Fr: Simon Davis
Sent: 06 October 2014 14:17
To: 'Peter Champion'
Subject: RE: BR/71/12 - preparing NMA & DOC applications

PROJECT		Residential Development at Sylvan Way, Bognor Regis	
SUBJECT		Plot 4 Elevations Plot 1 as plot 4 but handed	
SCALE	DATE	DRAWING No	Rev
1:50	Mar 2013	2012 / 15 / 15	B
DRAWN	CHECKED

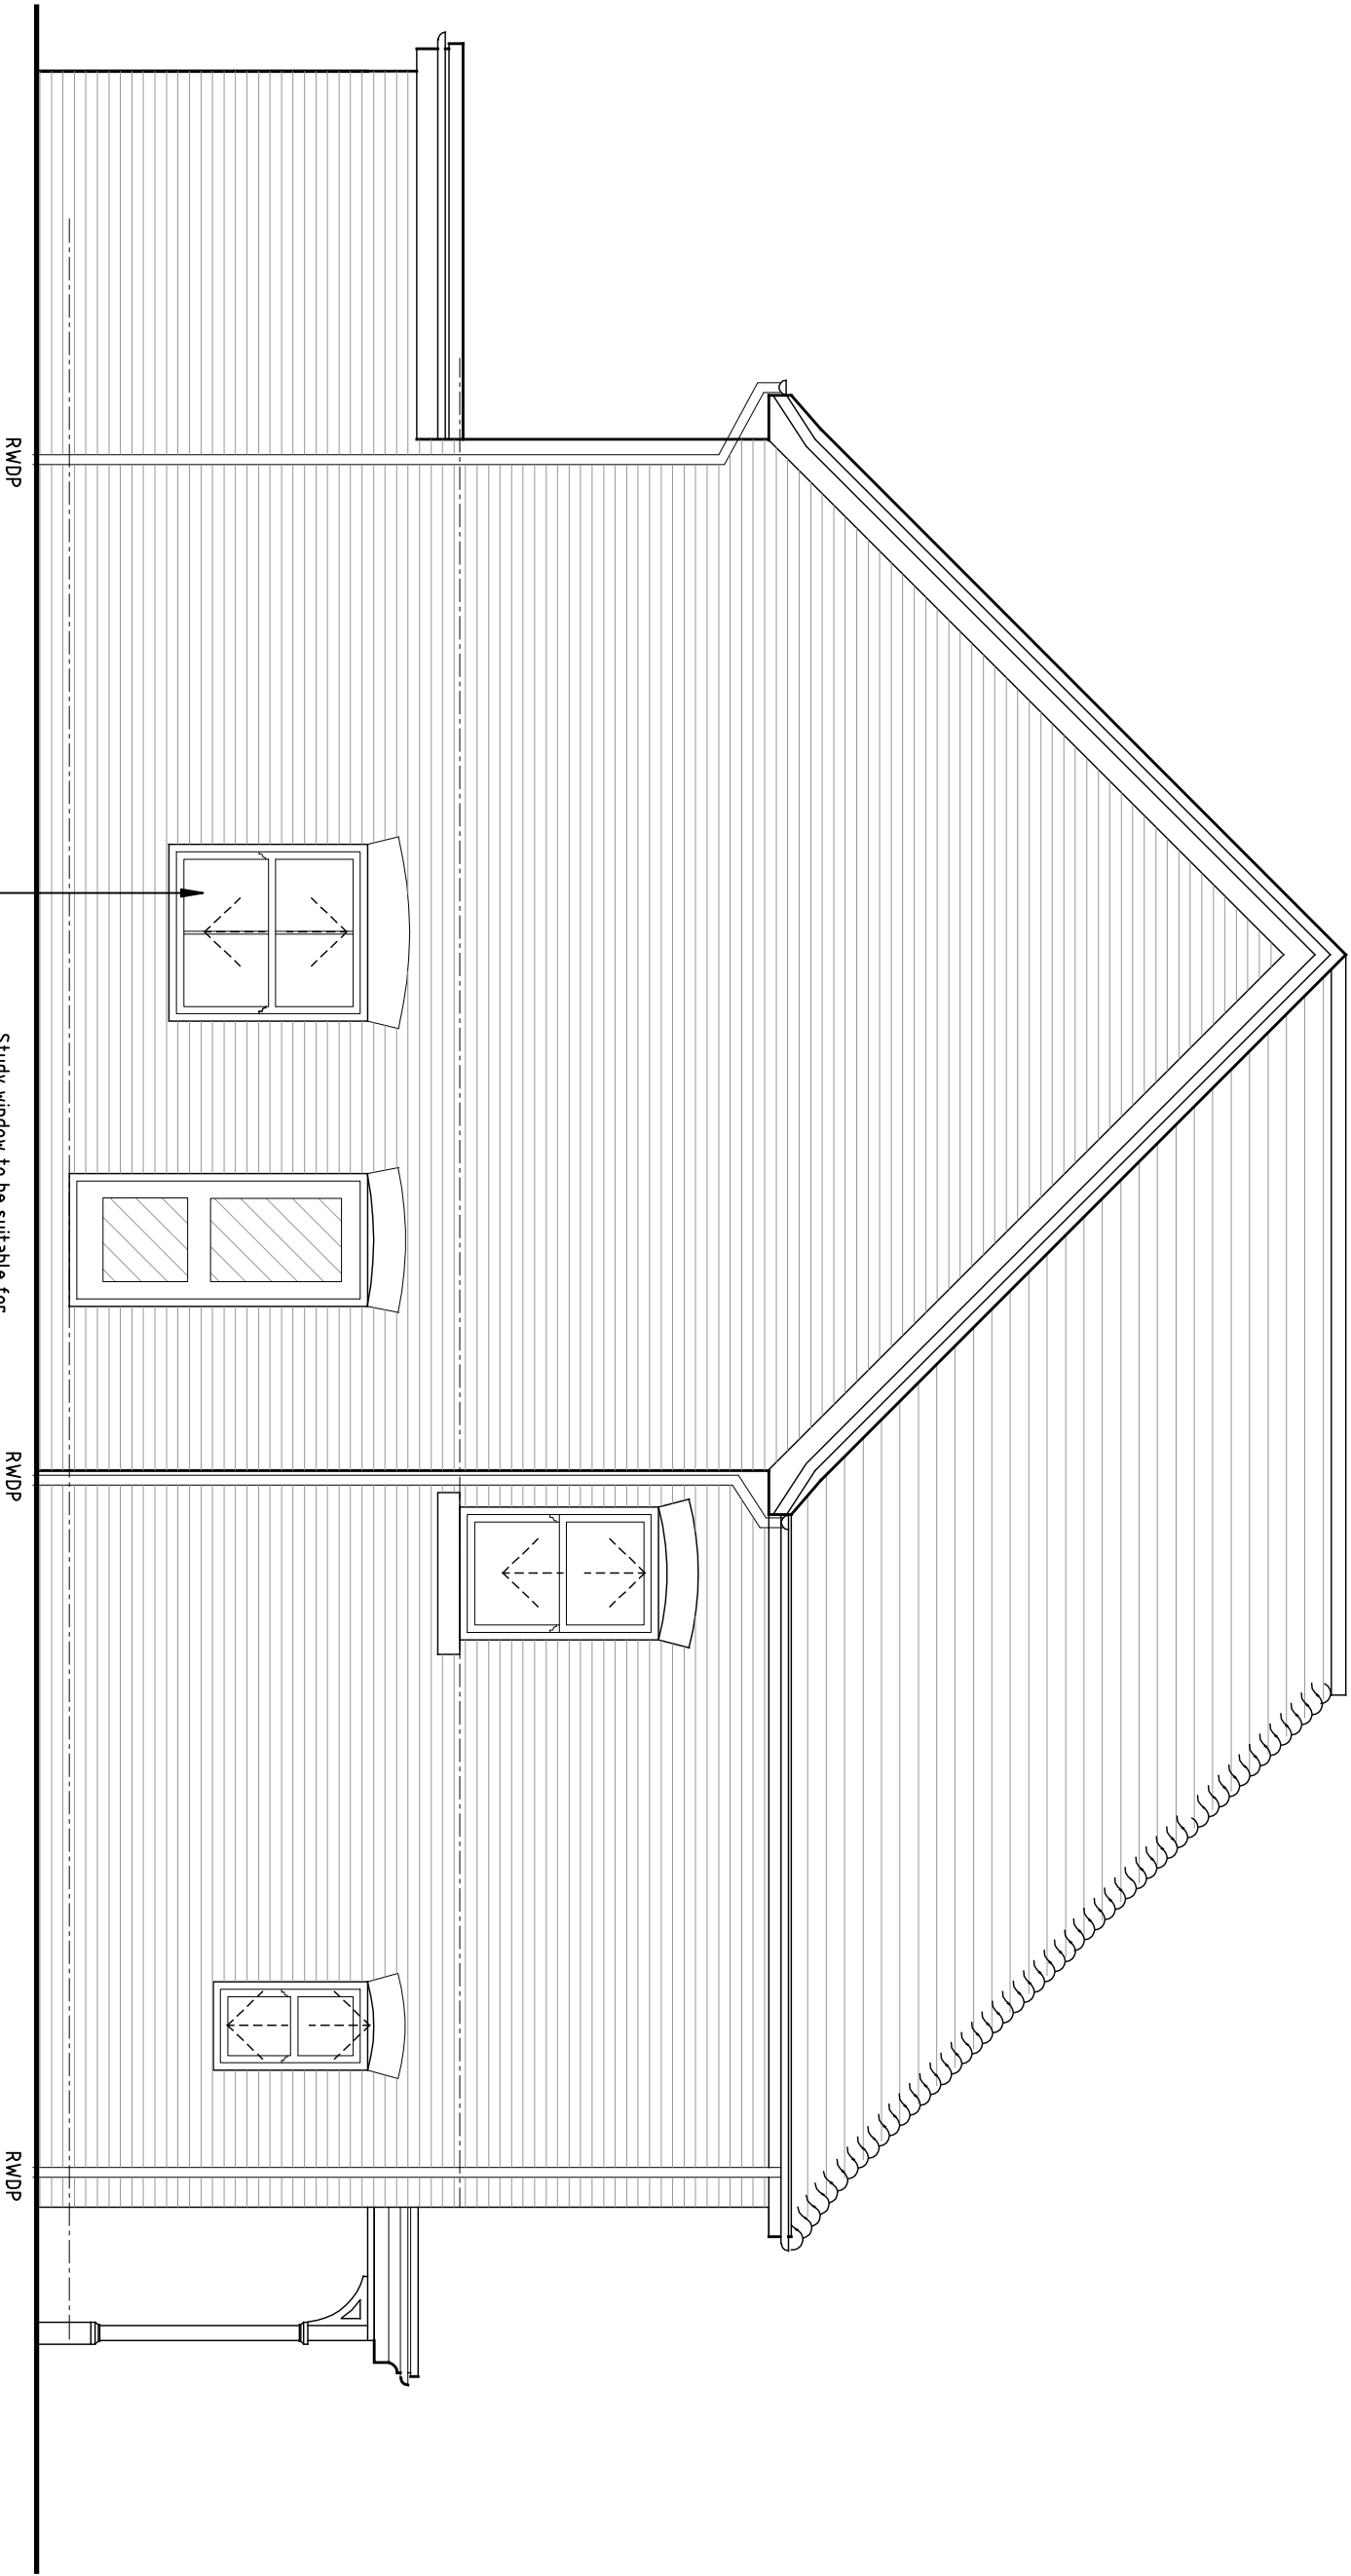
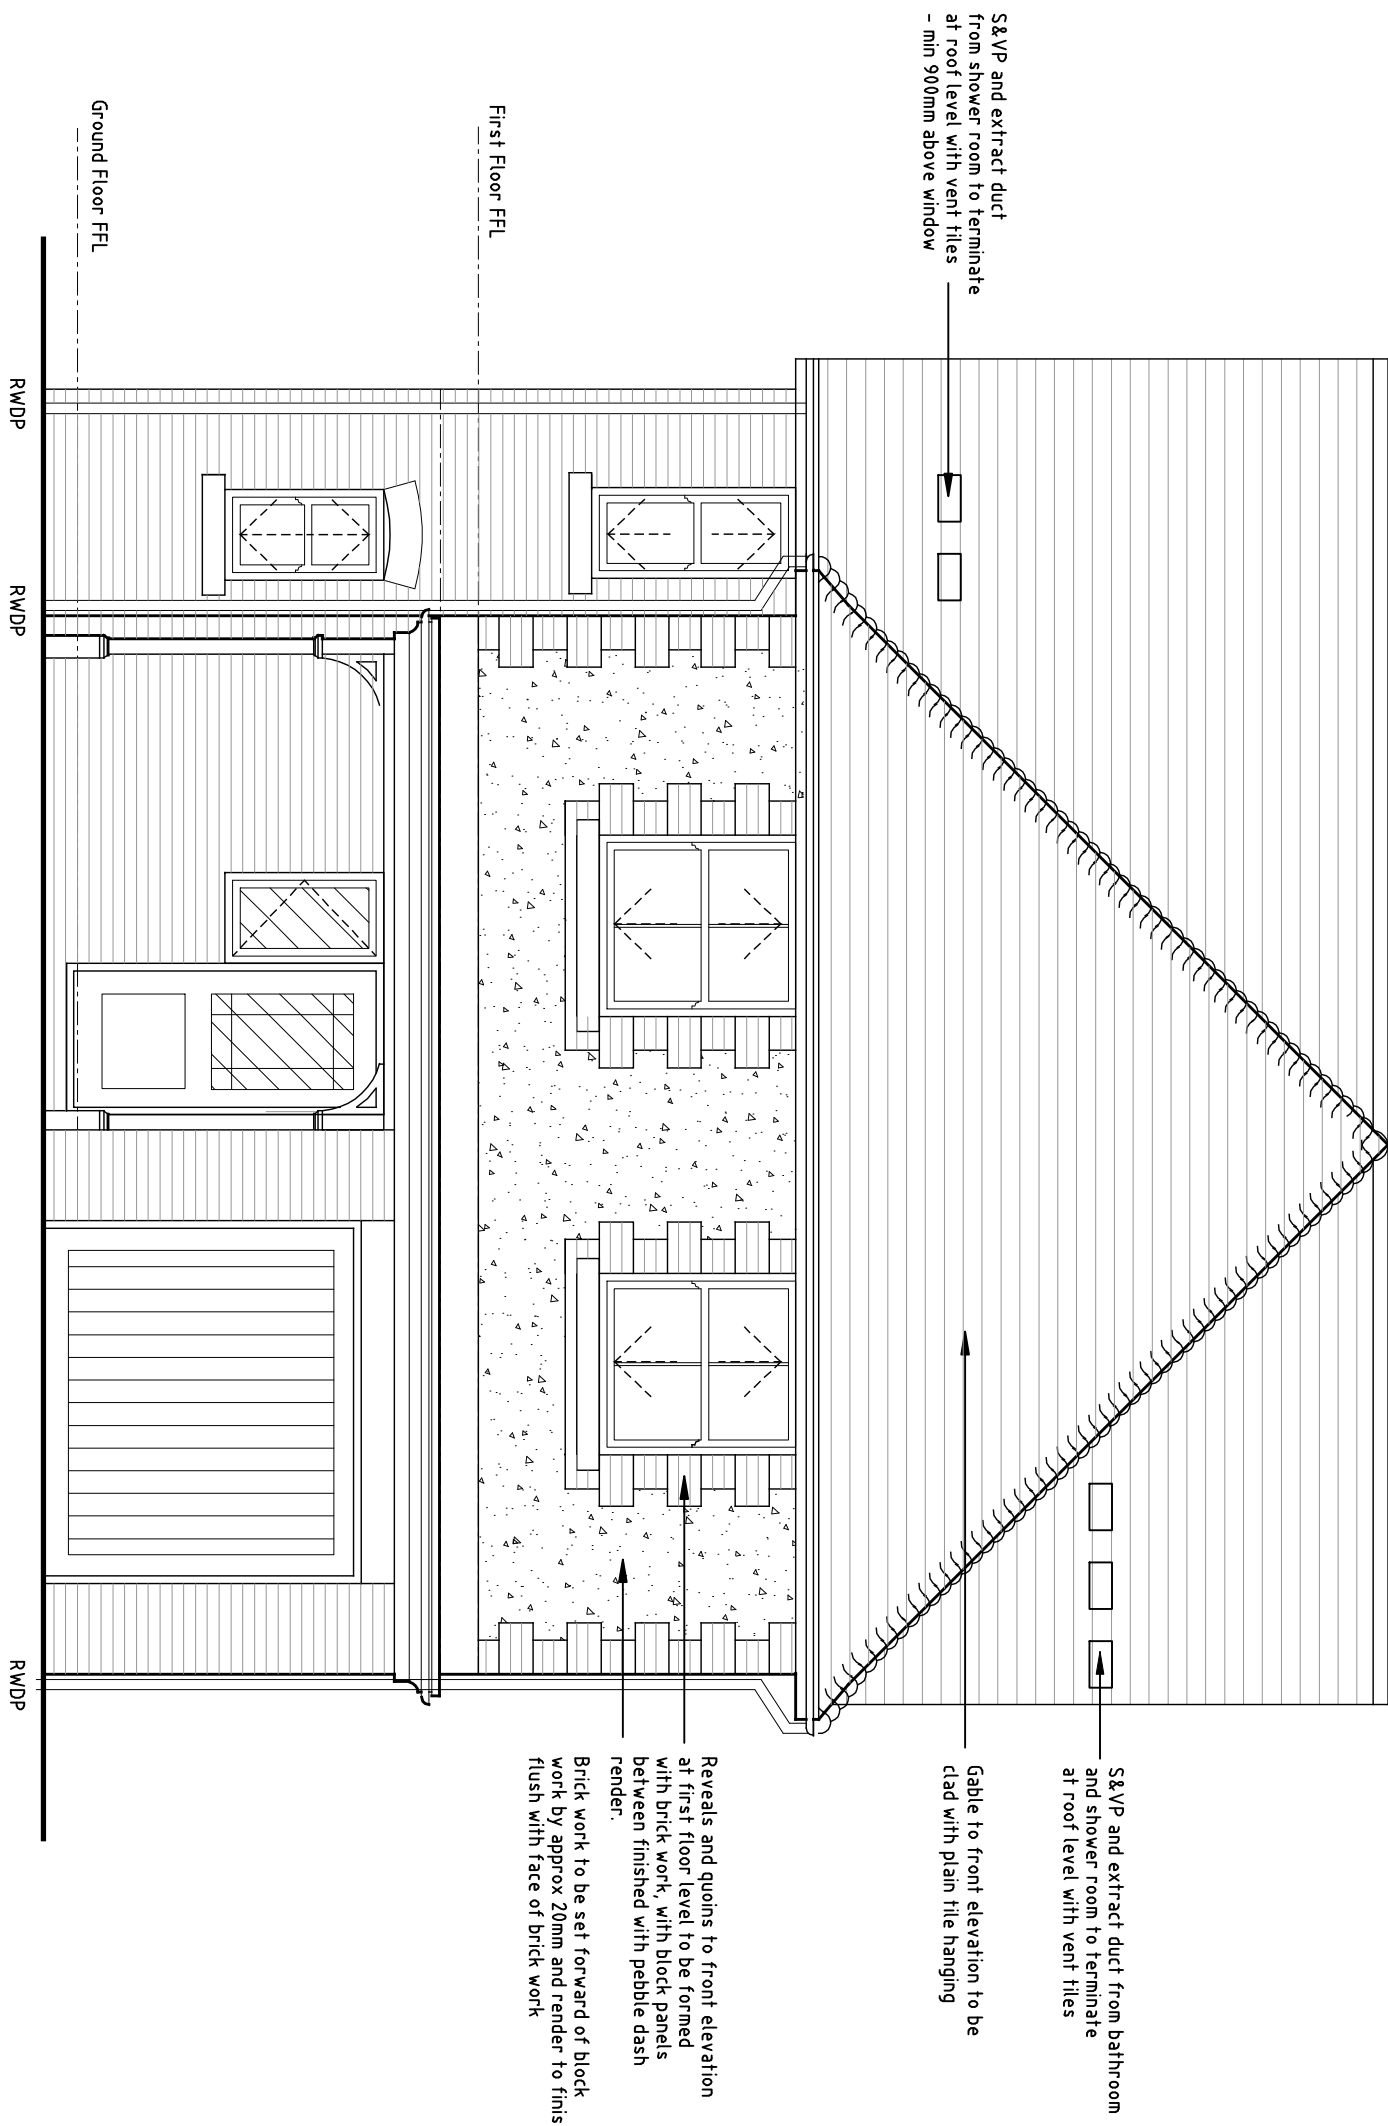
③ ~~TZ EXTENSION~~ TO 1m EXTENSION TO REAR OF PLOT 4 TO MATCH 1-3: IMPACT ON SANDY COODE? *

④ ROOF OF REAR 'EXTASIONS' TO BE FLAT WITH SINGLE CANTILEN:

LD OK AS REDUCES IMPACT ON SANDY COODE.

⑥ Δ CASE OF PLOTS 4+1 TO HIPPO: OK NO OBSERV.

* BUT WITHIN 1m DISTANCE AND
LESS IMPACT DUE TO Δ FROM PITCHED
TO FLAT ROOF.
